Director, Sydney Central Urban Renewal
Department of Planning and Environment,
GPO Box 39,
Sydney, NSW 2001

Concept State Significant Development Application – SSD 18_9579 Crows Nest Overstation Development - Submission

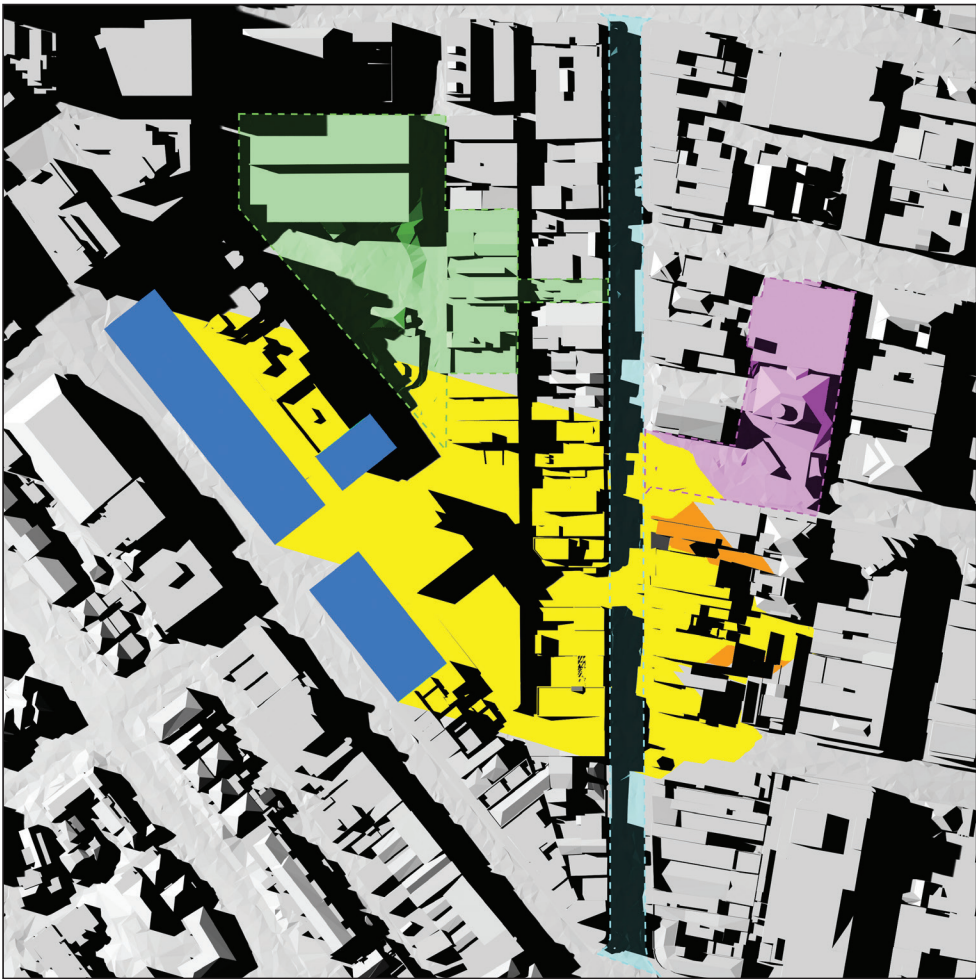
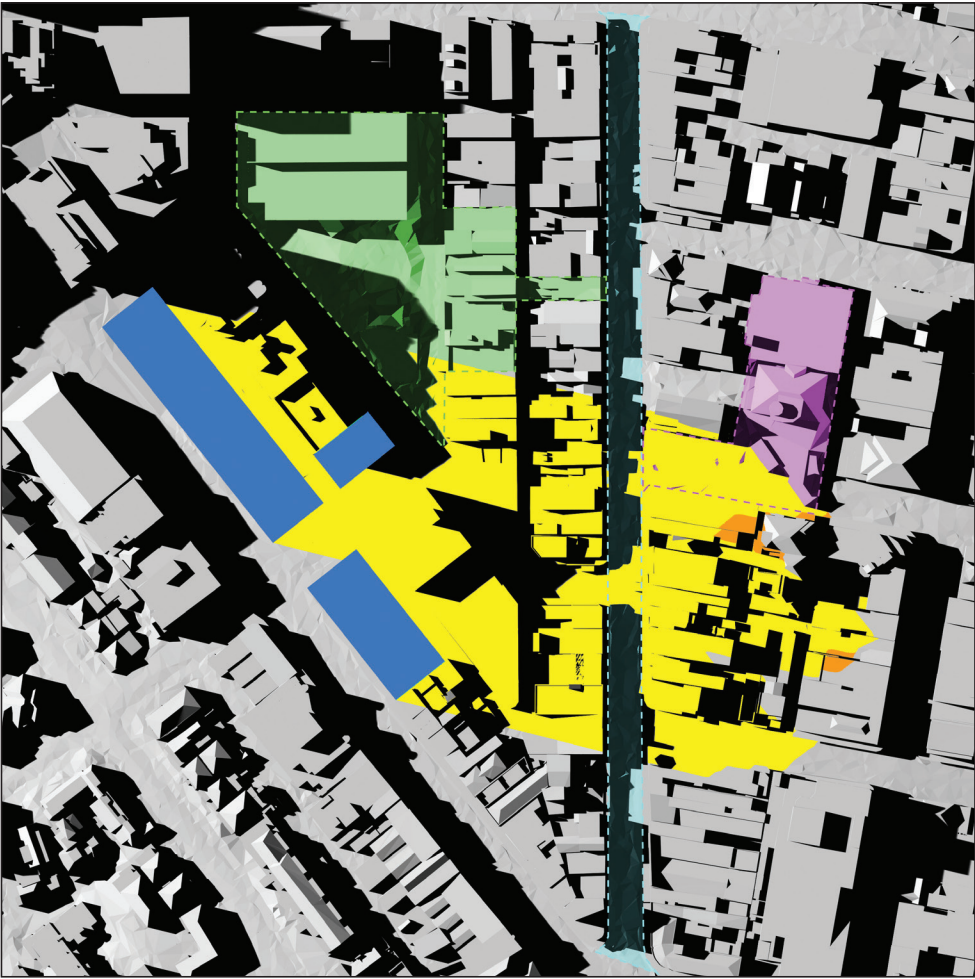
- I object to the overshadowing of Nicholson Street, Hume Street Park, Willoughby Road and Ernest Place in particular year-round, not just between 9.00 am and 3.00 pm.
